NSW RURAL FIRE SERVICE

Your reference: SSD 5175 MOD 3 & SSD 8588
Our reference: D17/2228

Notice of Exhibition Eastern Creek Business Hub - Retail Component, Rooty Hill

Figure 2: Development plan

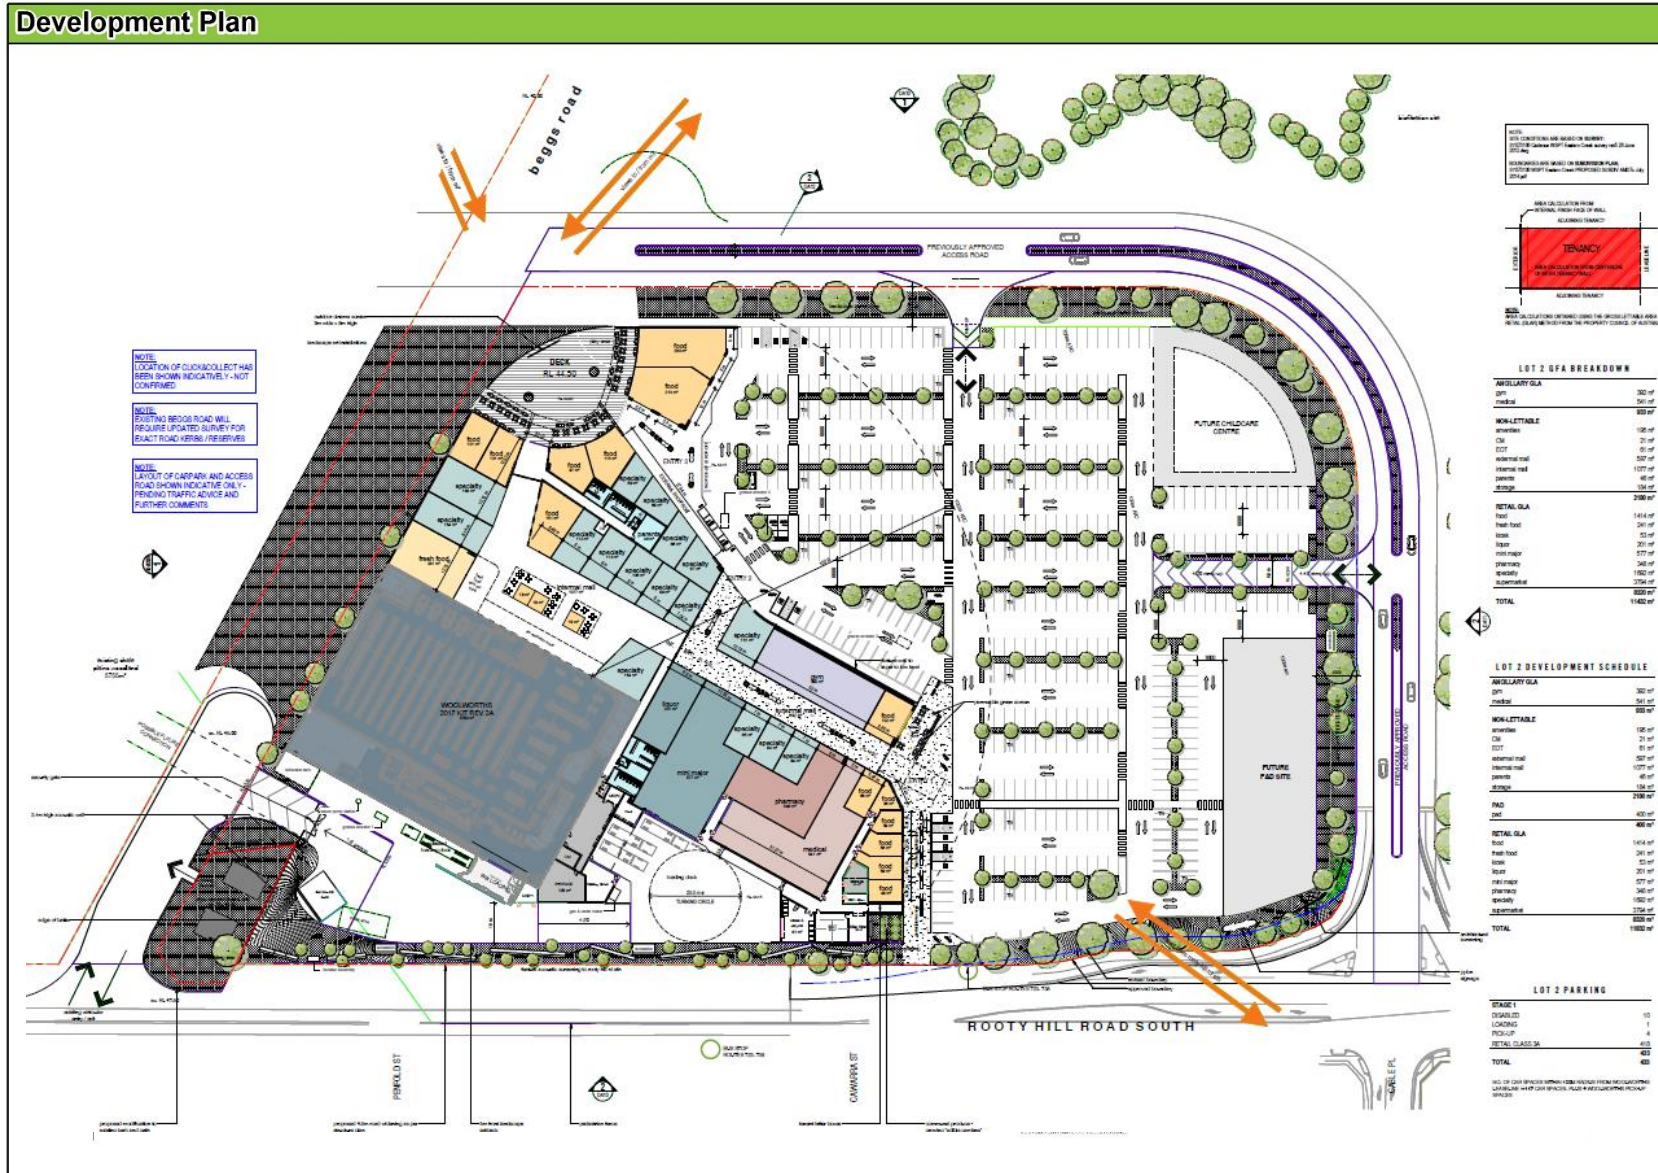
- Further evidence is required which demonstrates that the future child care centre can achieve the required minimum Asset Protection Zones (APZs) within the subject site in accordance with Table A2.6 for Special Fire Protection Purpose (SFPP) developments, in accordance with *Planning for Bush Fire Protection (PBP) 2006* and as requested in NSW RFS correspondence dated 17 July 2017.
